## Application for a Non-Material Amendment Following a Grant of Planning Permission

demolition of the existing dwelling and erection of a two storey plus lower ground floor level detached dwellinghouse with integral garage, associated refuse/recycling store, cycle store, amenity space and provision of 2no.off street parking spaces

22/0501/ful

APPROVED SIDE ELEVATION

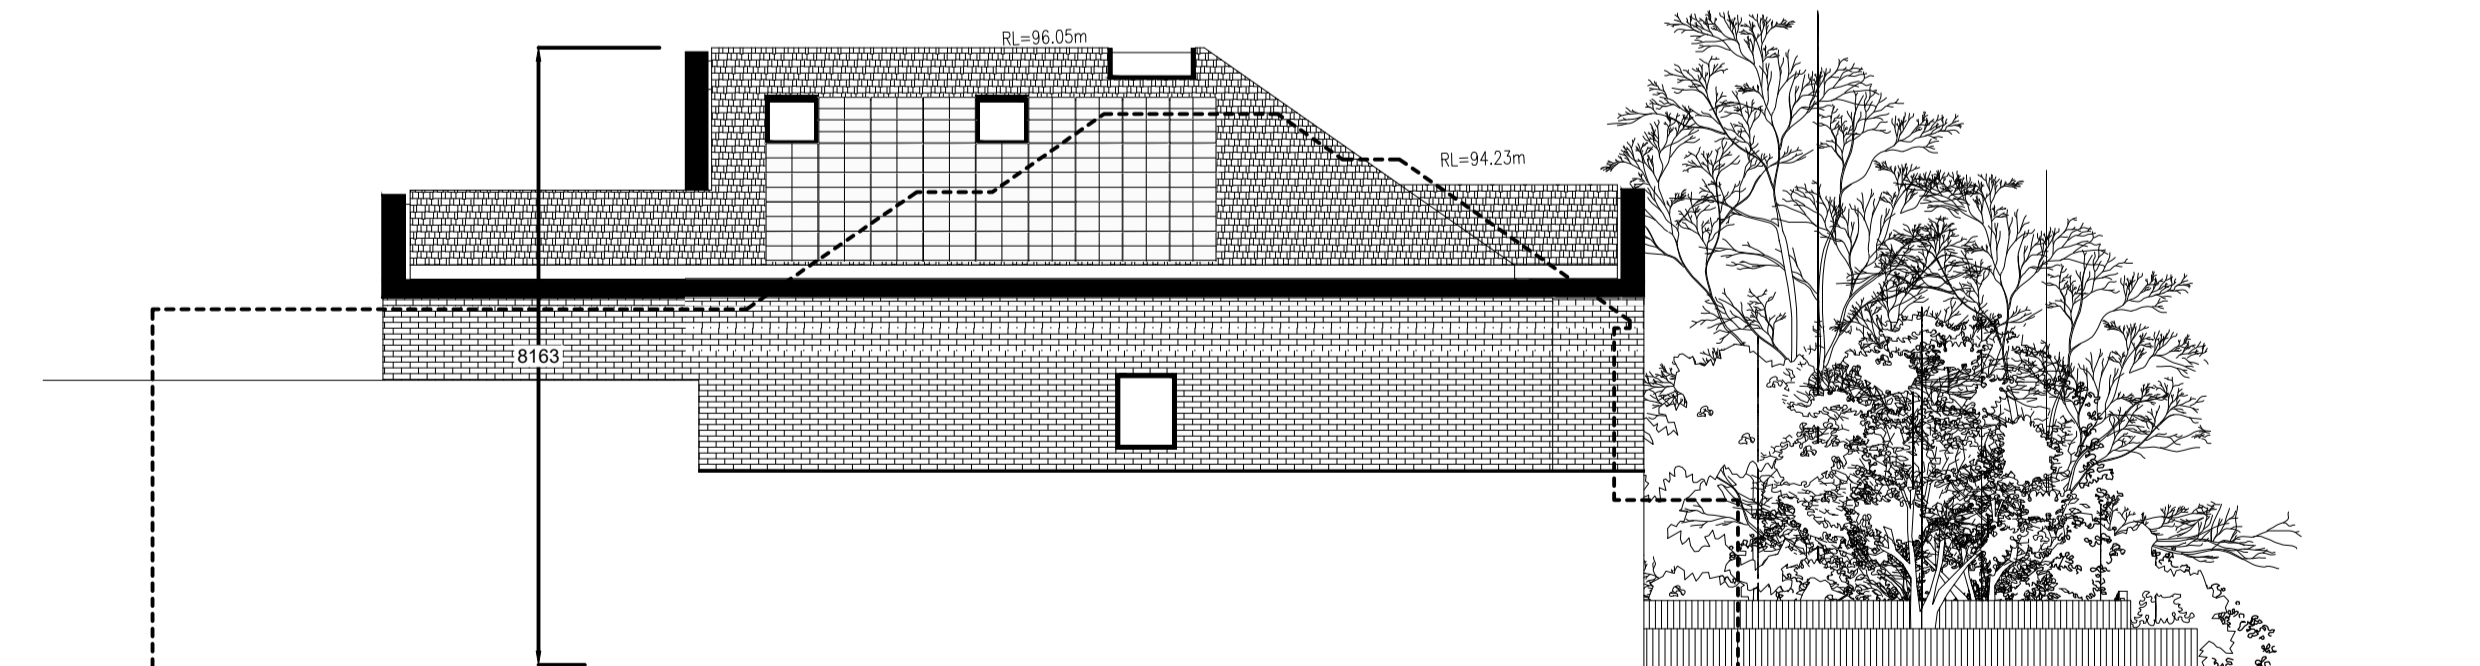
the back addition part of the build has been extended by 500mm

to rectify the build
